CITY OF MERCER ISLAND

REVISION/DEFERRED SUBMITTAL FORM

Site Address 7450 N Mercer Way

Permit Number 1904-048

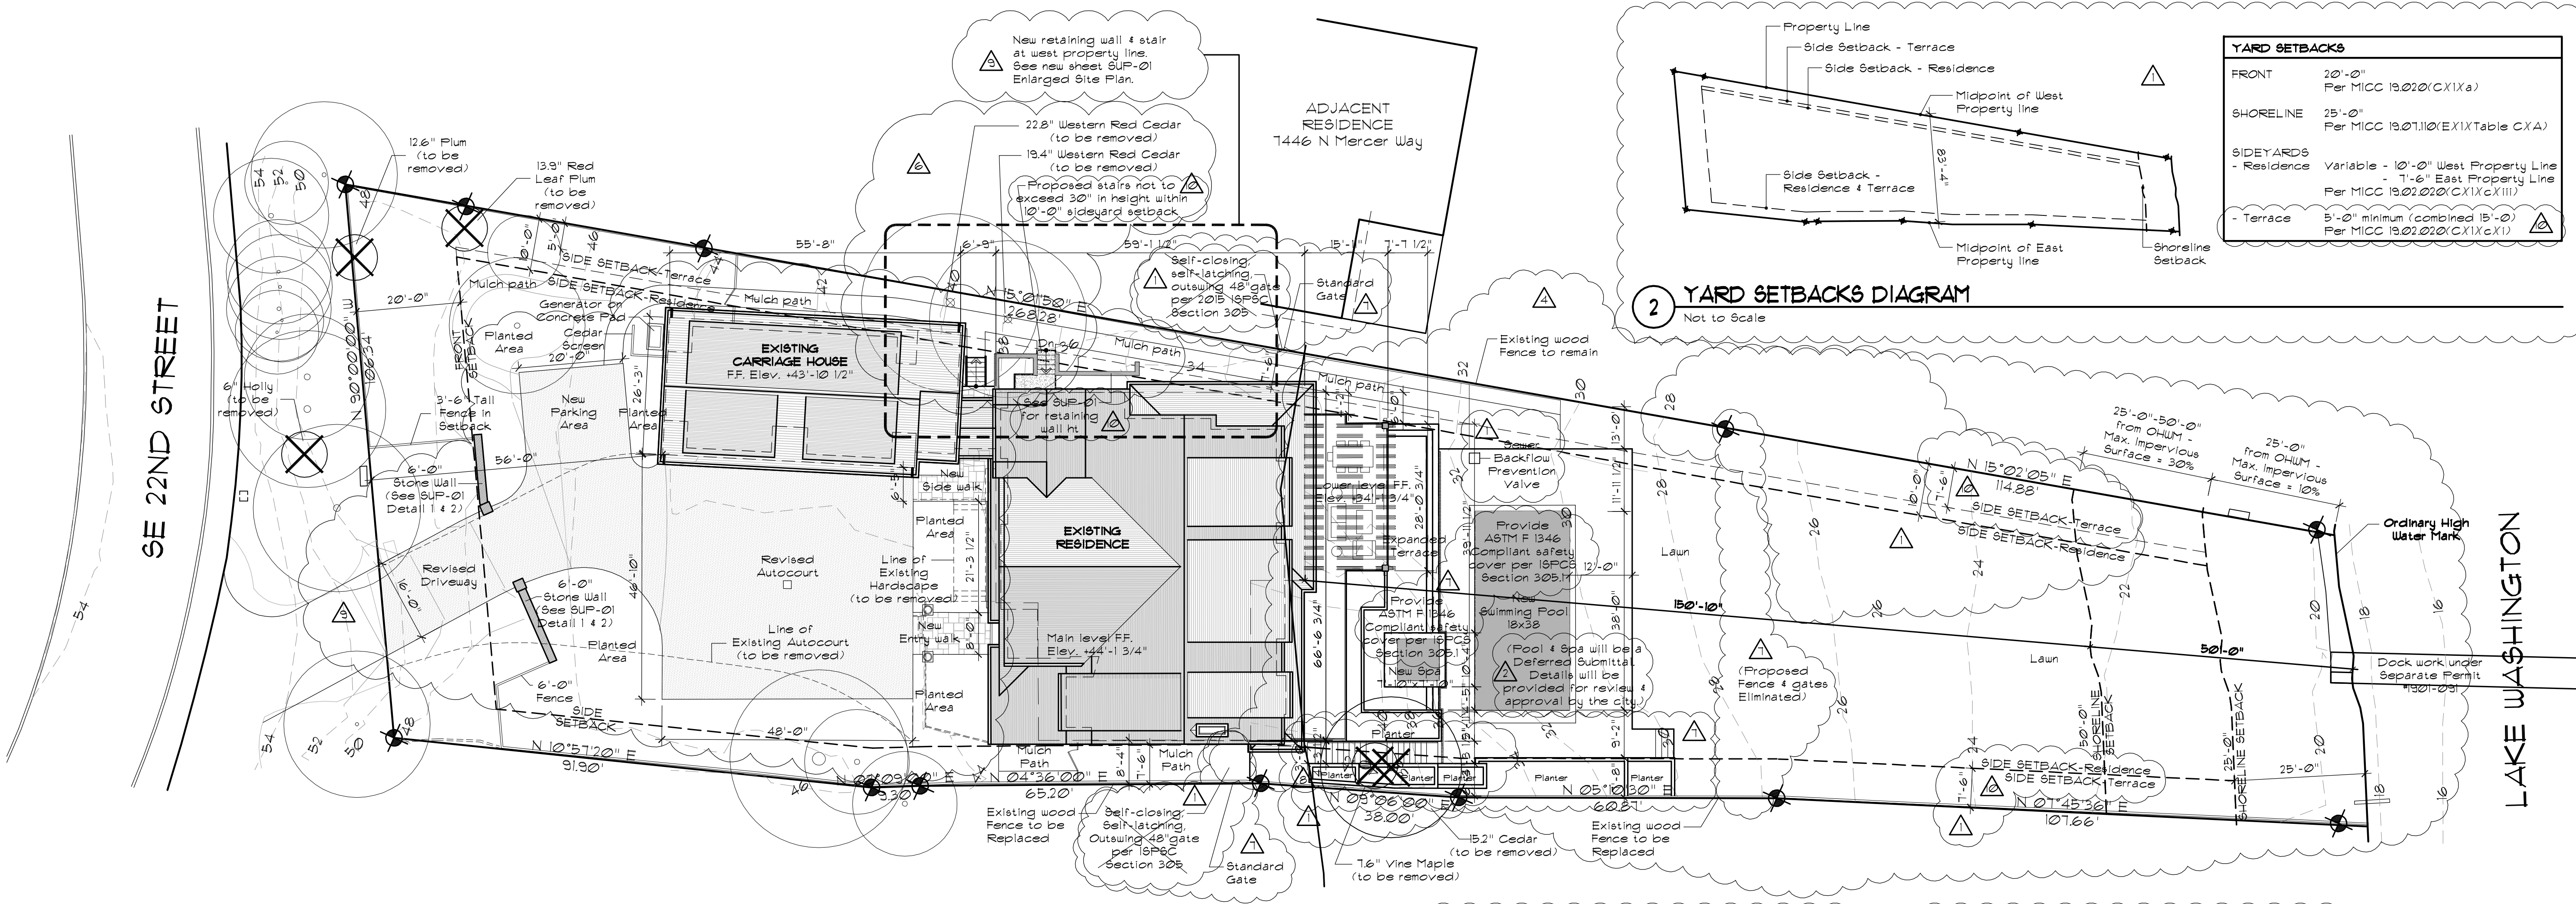
Sheet #	A-1.1	Site Plan - Reconfigured driveway & parking area. New retaining wall
Sheet #		and lower stair along west property line.
Sheet #	A-1.3	Zoning Diagrams (Detail #2) impervious coverage revised.
Sheet #	A-3.2	Exterior Elevations (Detail #1) west elevation revised
Sheet #	SUP-01	Enlarged Site Plan & Misc Details (new sheet)
Sheet #	C-1of2	Civil Site Improvement Plan - Updated to reflect site plan changes
Sheet #	C-2of2	TESC & SWPP Plan - Updated to reflect site plan changes
Sheet #		
Sheet #		
Sheet #		
Sheet #		
Sheet #		
Sheet #
